## *Rezoning Petition Review*

**Rezoning Petition #:** 20-42

**Location of Property:** Approximately 0.24 acres located east of Tryon St, south of Trydan Dr and west of Dewitt Ln,

SHEET NUMBER:
RZ-1

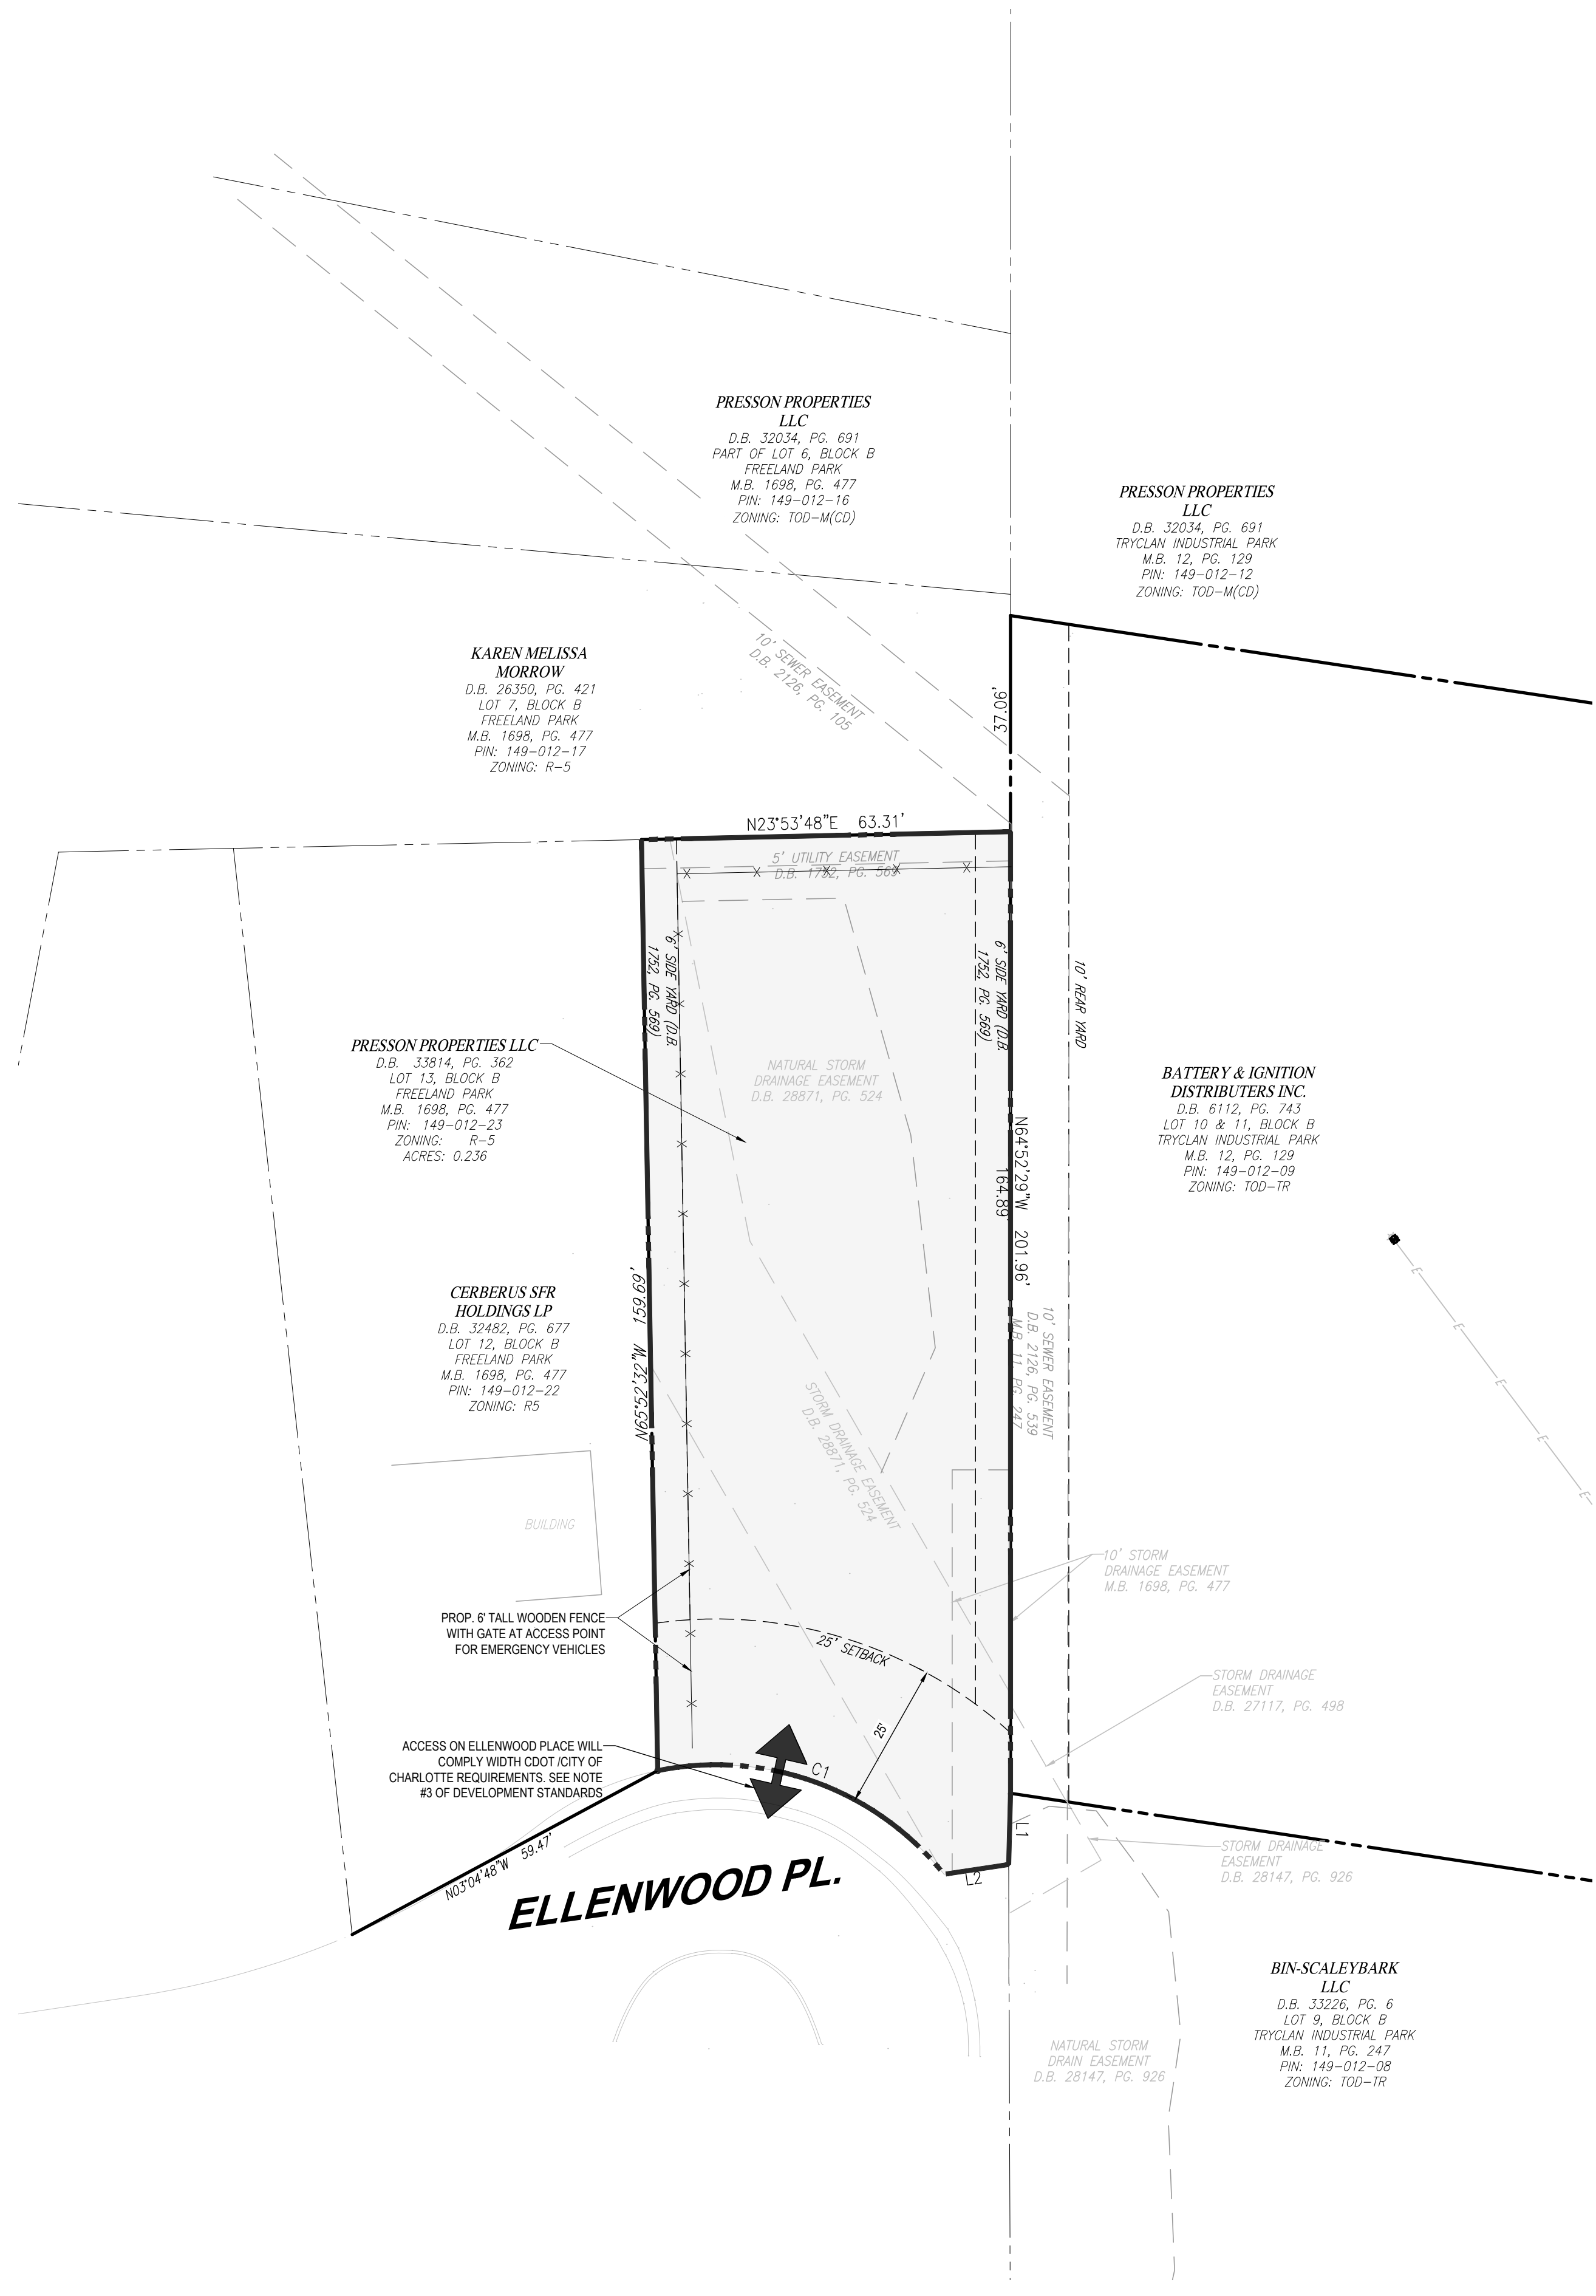
**Recommendations Concerning Storm Water:** Charlotte-Mecklenburg Storm Water Services has a permanent storm drainage easement (SDE) and a natural storm drainage easement (NSDE) on the parcel for this rezoning request. These easements can be found in book 28871 pages 524-528. Please note that no buildings or structures are permitted over and across these easements.
